Approval of reserved matters (access, appearance, landscaping, layout and scale) following outline permission Y/19/16/OUT for 108 residential dwellings, with associated parking, road/footway/cycleway provision, open space, landscaping, surface water attenuation and ancillary works.

Land off Burndell Road Yapton

Thank you for your internet representation made on 15th January 2019 which has been recorded as **'an objection'** with the comments as follows:

PROPOSED SITE PLAN

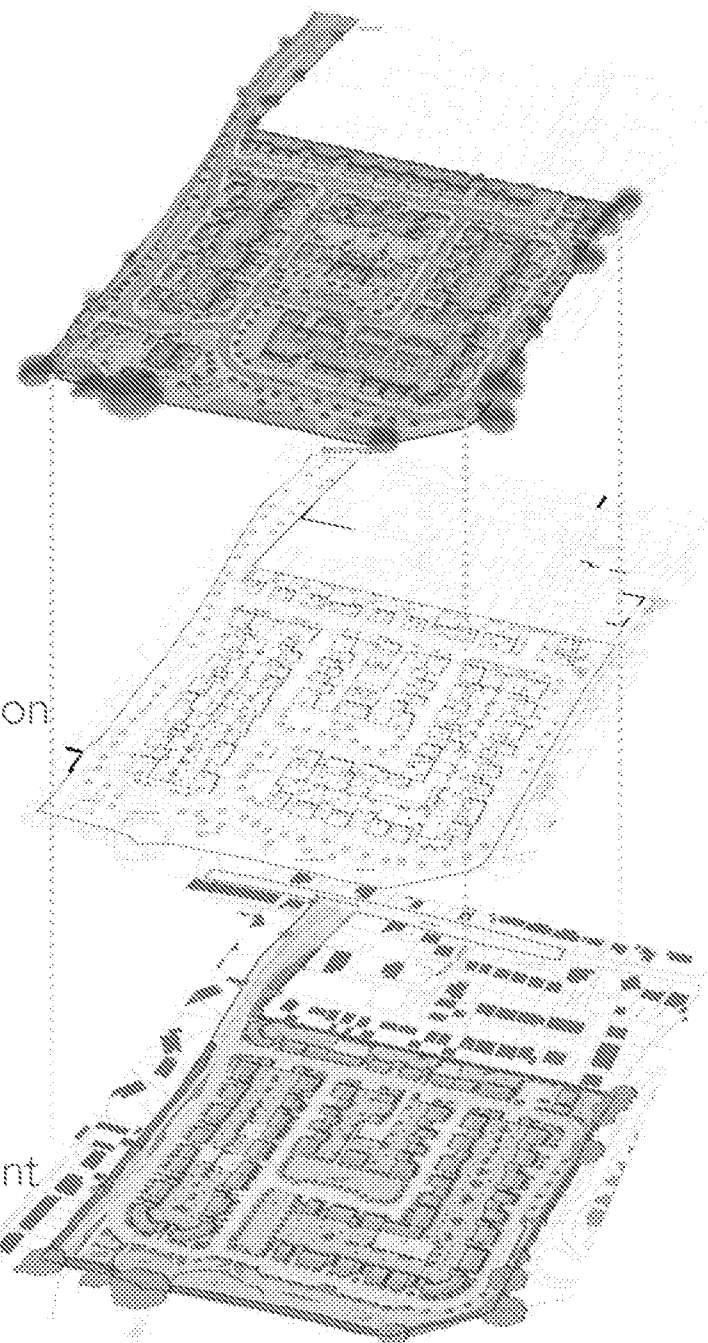
Behind our property and adjacent properties there is a strip of hedge and trees which are shown on the site plan as a green strip. Could you please confirm that this area of hedgerow and trees will not be damaged or removed in any way. It is an area of natural habitat for the bird life and wildlife in our area which is vital to our environment. This strip of land is shown on our title deeds as a "ransom strip" and we understood that it had to remain.

I also note that plots 1-16 on the site plan appear to have dormer windows in the roof at the rear of the property. This means windows overlooking Fellows Gardens one floor higher than the current properties in Fellows Gardens and is not in keeping with the current planning allocation on neighbouring sites. I note Velux windows have been allowed at the rear of properties which overlook neighbouring rear gardens which is less intrusive to the surrounding properties but allowing dormer windows to the front of the property.
